**Western Sydney Stadium (Stage 2 Design and Construction), Parramatta (SSD 8175)
Notice of Exhibition**

Thank you for your letter dated 7 March 2016 requesting Transport for NSW (TfNSW) comment on the above.

This letter is a TfNSW and Roads and Maritime Services joint response. TfNSW and Roads and Maritime Services support the overall proposal and would like to continue to work with Venues NSW to achieve better traffic and transport outcome for the proposed stadium.

Table 6.1 – Specific Potential Mitigation Measures

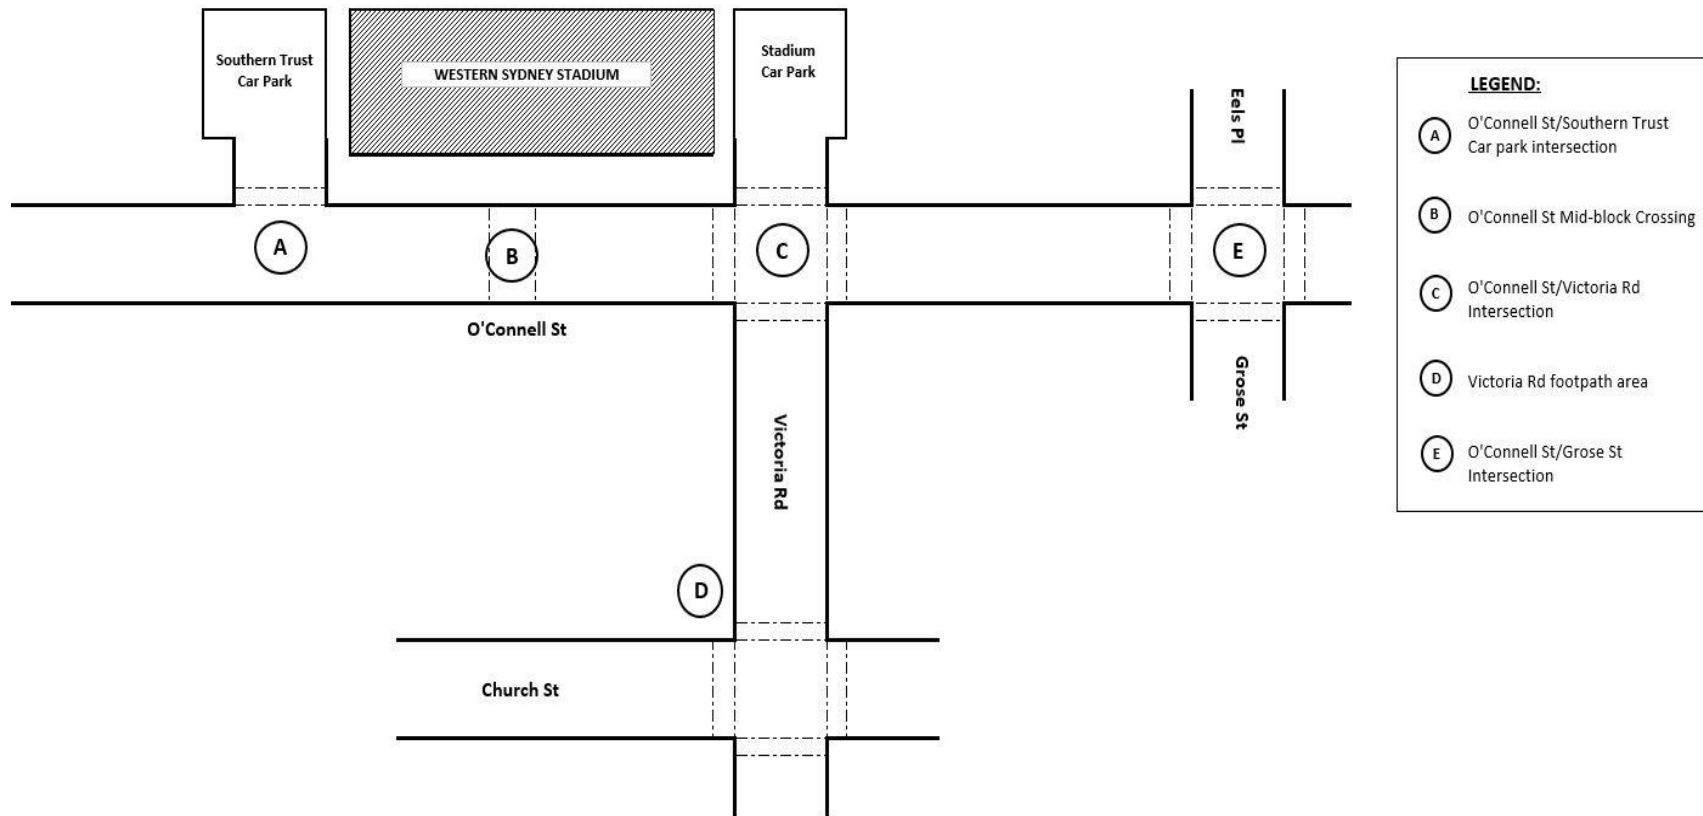
Table 6.1 of the Traffic Report outlines various mitigation measures for key intersections along O'Connell Street. It is advised that:

- The efficiency of O'Connell Street connectivity is of great importance to the overall greater Parramatta CBD due to the following reasons:
 - O'Connell Street forms part of the Parramatta Inner Ring Road; and

- With the introduction of light rail in Church Street, more traffic in North Parramatta will be diverted to O'Connell Street.
- The proposed closure of O'Connell Street would restrict buses (particularly special event buses) ability to operate to/from its origins and the site. The closure of O'Connell Street is not supported without:

- Detailed traffic and transport impact assessment that demonstrate the following:
 - Alternatives to any road closures have been investigated in detail in consultation with TfNSW, Roads and Maritime Services and City of Parramatta; and

- Any road closures would not have impact on the general traffic and bus operation and pedestrian and cyclist safety.
 - Crowd modelling for the public domain area for pre-game and post-game peaks to the satisfaction of TfNSW and Roads and Maritime Services; and

- Approval from TfNSW, Roads and Maritime Services and City of Parramatta.
- The Traffic Report indicates that the layout, capacity and operations of existing signalised intersections and connecting footpaths may require upgrades to accommodate future pre-game and post-game peaks. During events O'Connell Street needs to be carefully managed to keep crowds separated from traffic. The Traffic Report does not adequately address mitigation measures at the intersection of O'Connell Street and Victoria Road; and

- The proponent should liaise with TfNSW and Roads and Maritime Services to investigate alternatives to the closure of O'Connell Street during Special Events;
- A revised Traffic Report be submitted that comprehensively addresses the impacts of the proposed stadium increase on the signalised intersection of Victoria Road/O'Connell Street; and
- Further information be provided to support the proposal to remove the midblock pedestrian crossing and potential signalisation of the carpark entrance to the south of the stadium. The proponent should liaise with Roads and Maritime Services with regard to this proposal.
